**MODIFICATION REQUEST:
Royal North Shore Hospital
Acute Hospital and Community Health
Facility (MP 08_0172 MOD 4)**

Modification to Acute Hospital Building:
Redesign of Level 9 to accommodate 60 inpatient
beds.

Director-General's
Environmental Assessment Report
Section 75W of the
Environmental Planning and Assessment Act 1979

August 2011

**Figure 4: Approved Level 9 Floor Plan** set in context of earlier modification (MP08\_0172 MOD 3) for a helipad landing area circled red.

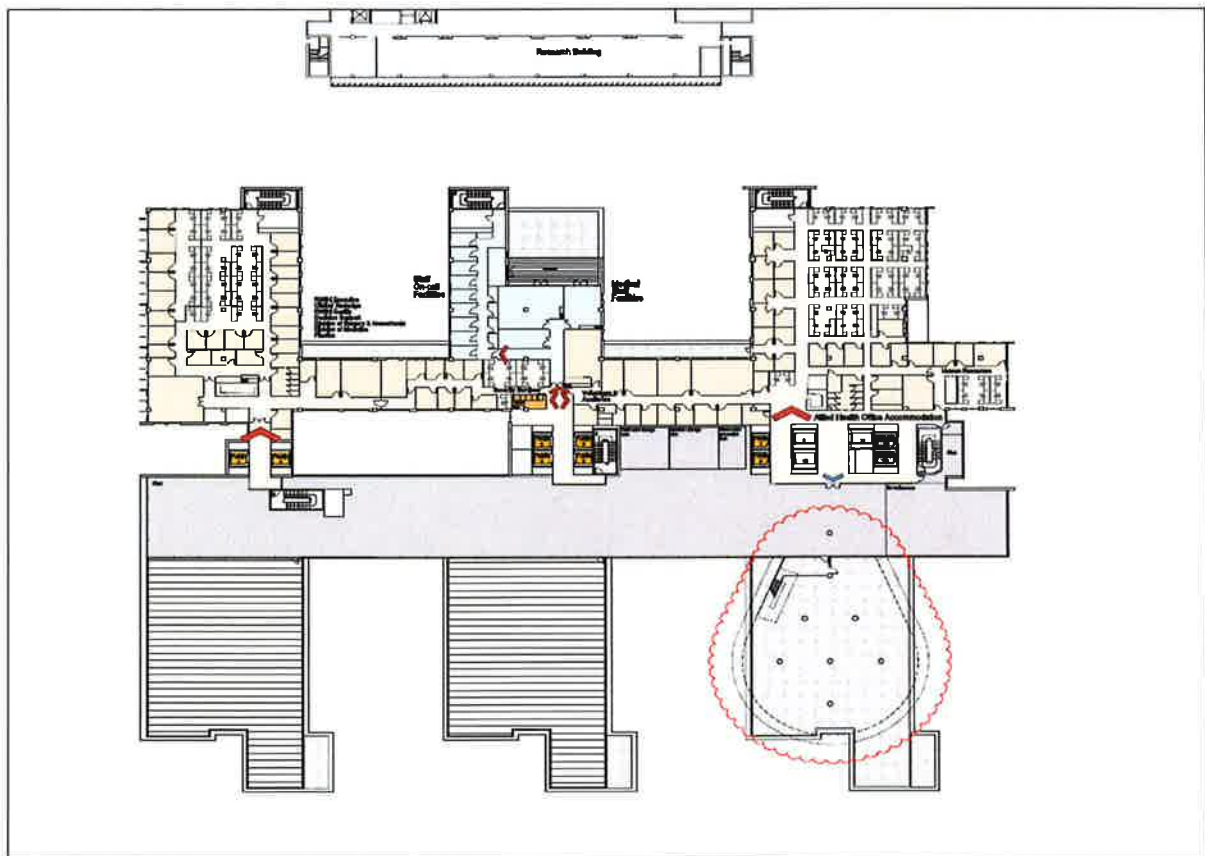
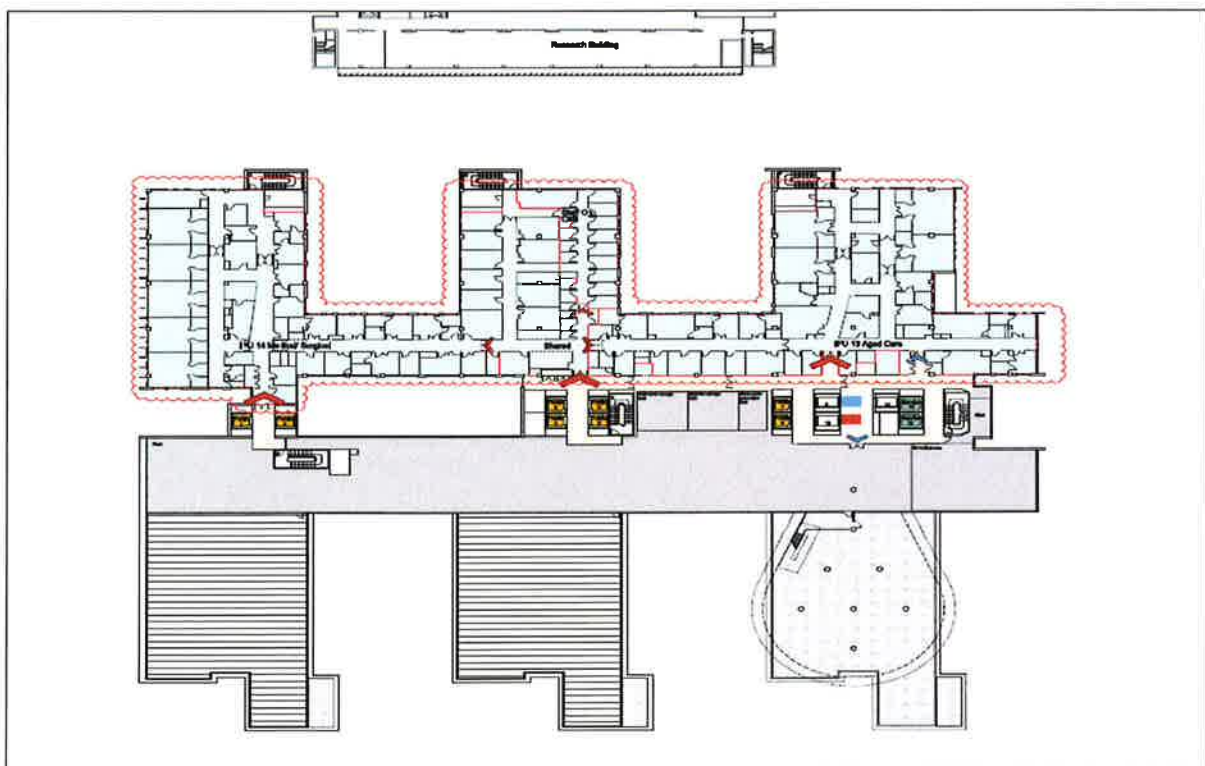
The Department is satisfied that the slight enlargement (120sq.m) and change to the fenestration pattern to Level 9 is limited in scope and will not result in adverse visual impacts or significant overshadowing impacts to its surroundings. The proposed modification is therefore supported.

## **APPENDIX D    APPROVED PARKING PLAN (MP08\_0172)**

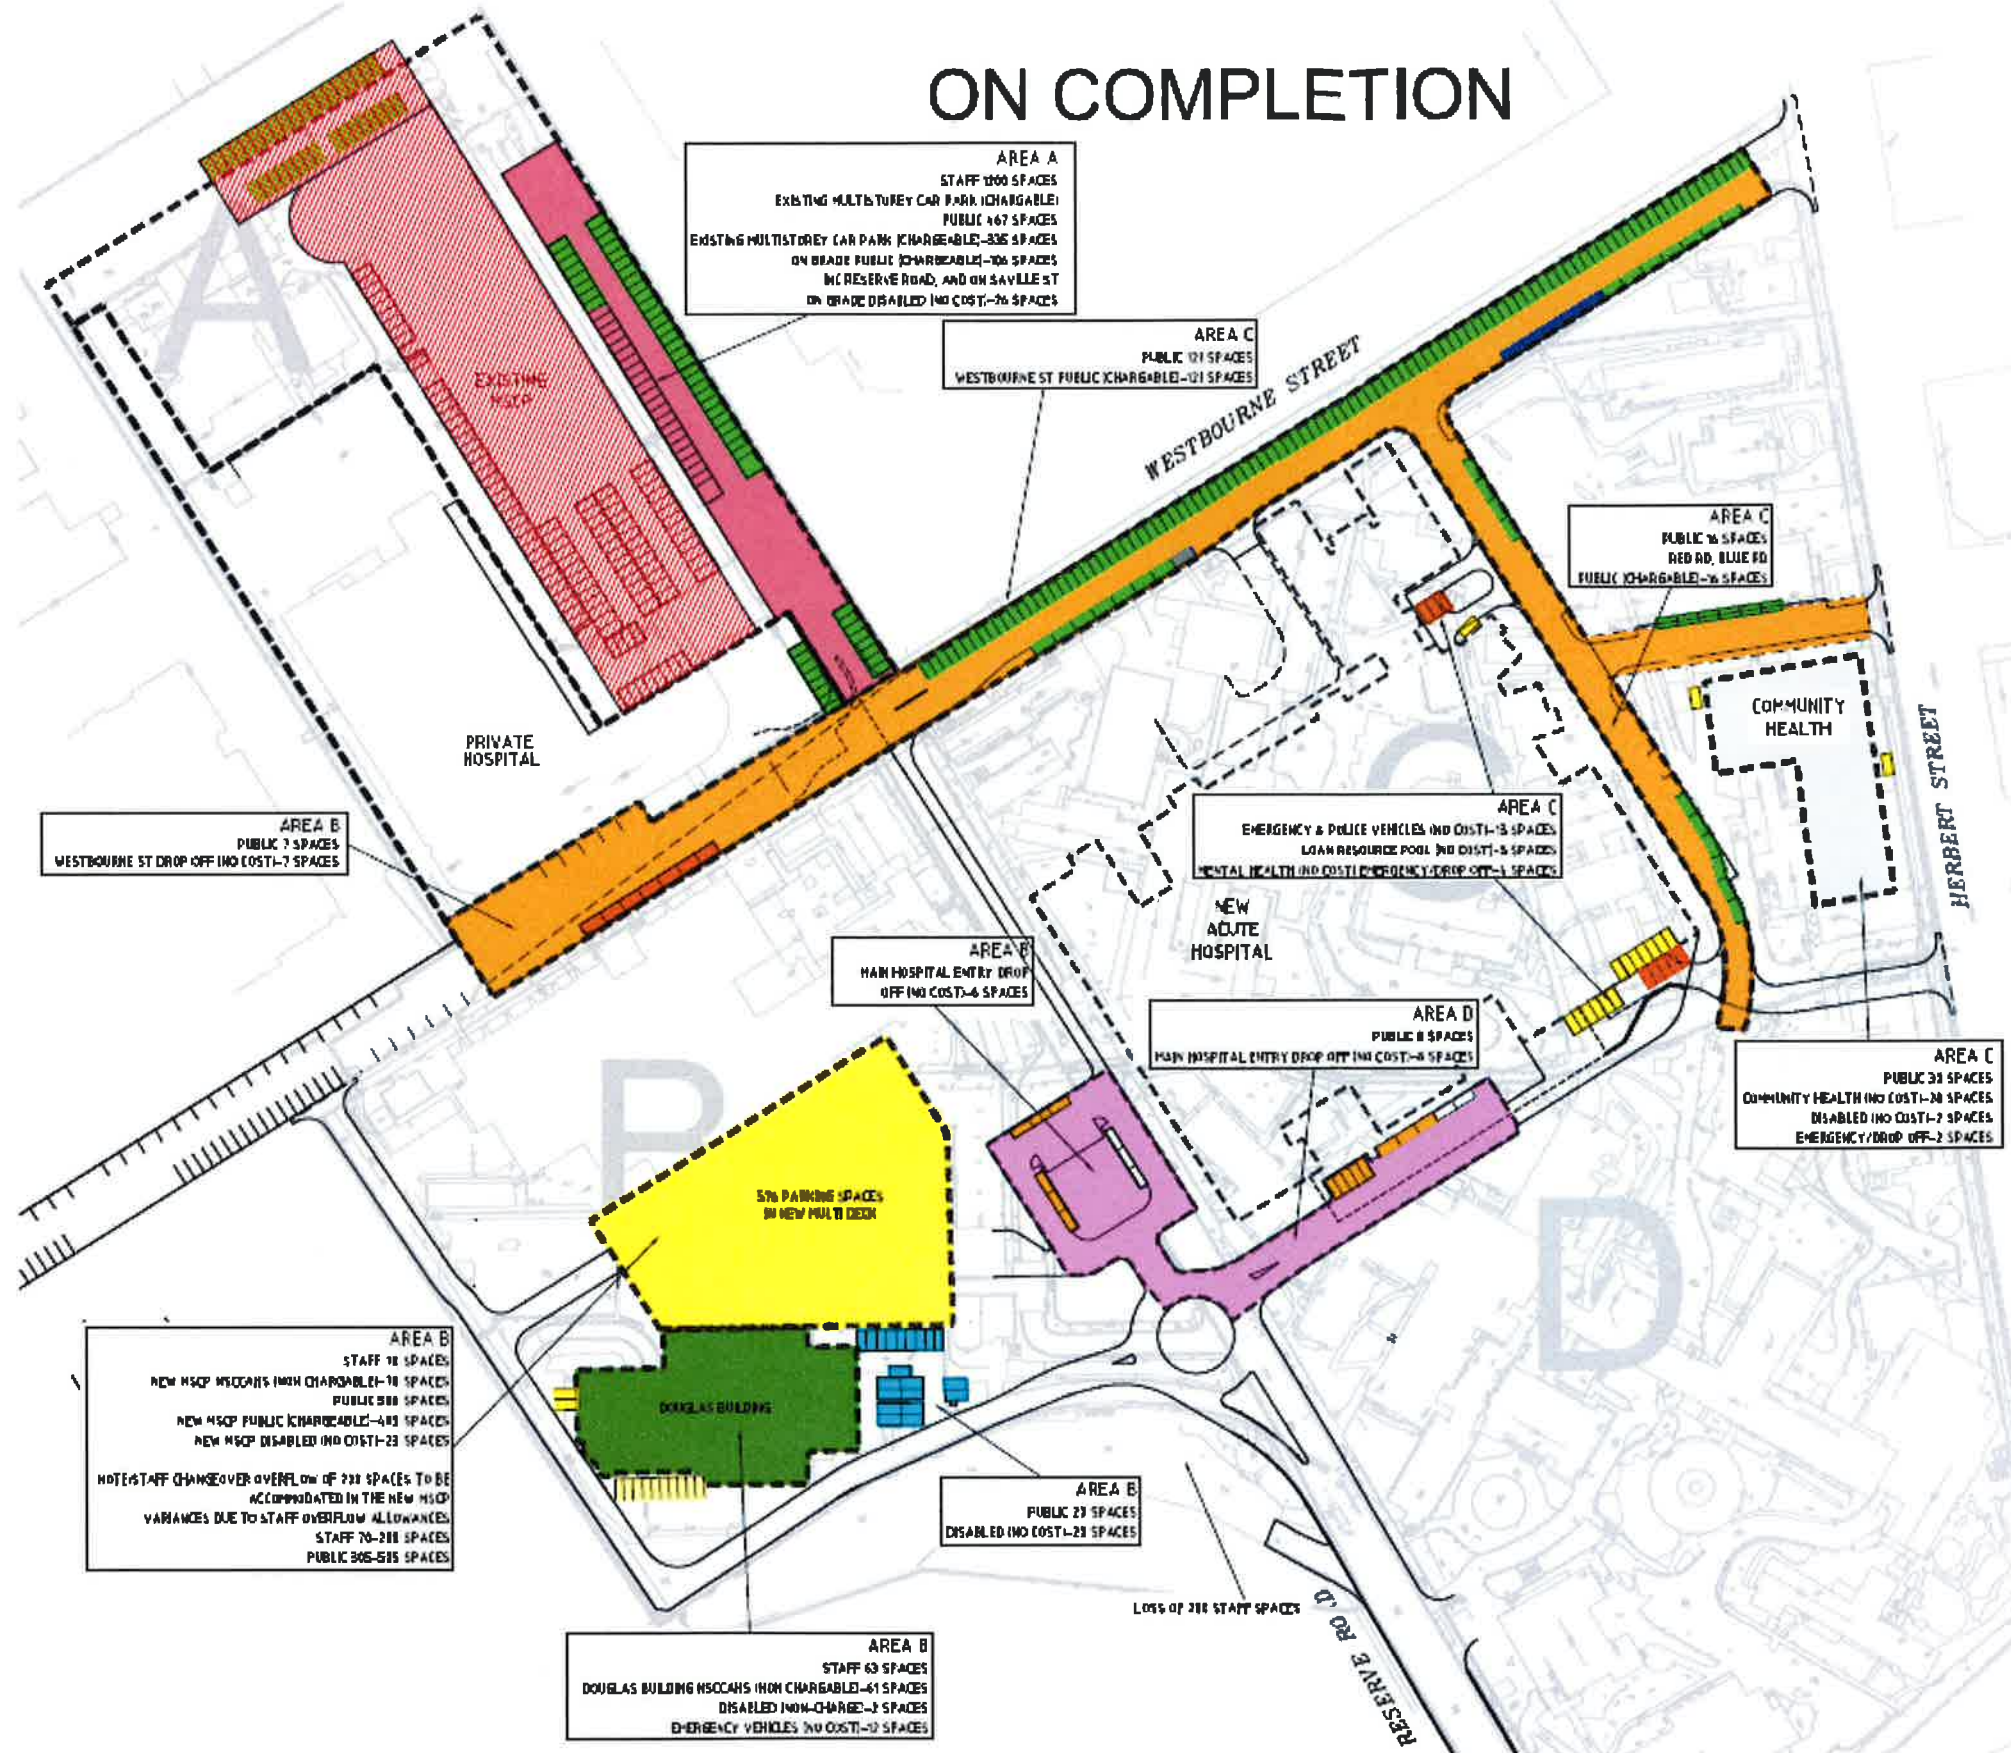
- The Department considers that it would be unreasonable to require further on-site visitor parking given the currently approved provision of 974 visitor spaces is more than double the 402 spaces previously provided on-site for a similar intensification of use. Also, the 20 visitor spaces required by the WDCP are only 2% of the overall visitor parking provision on site.
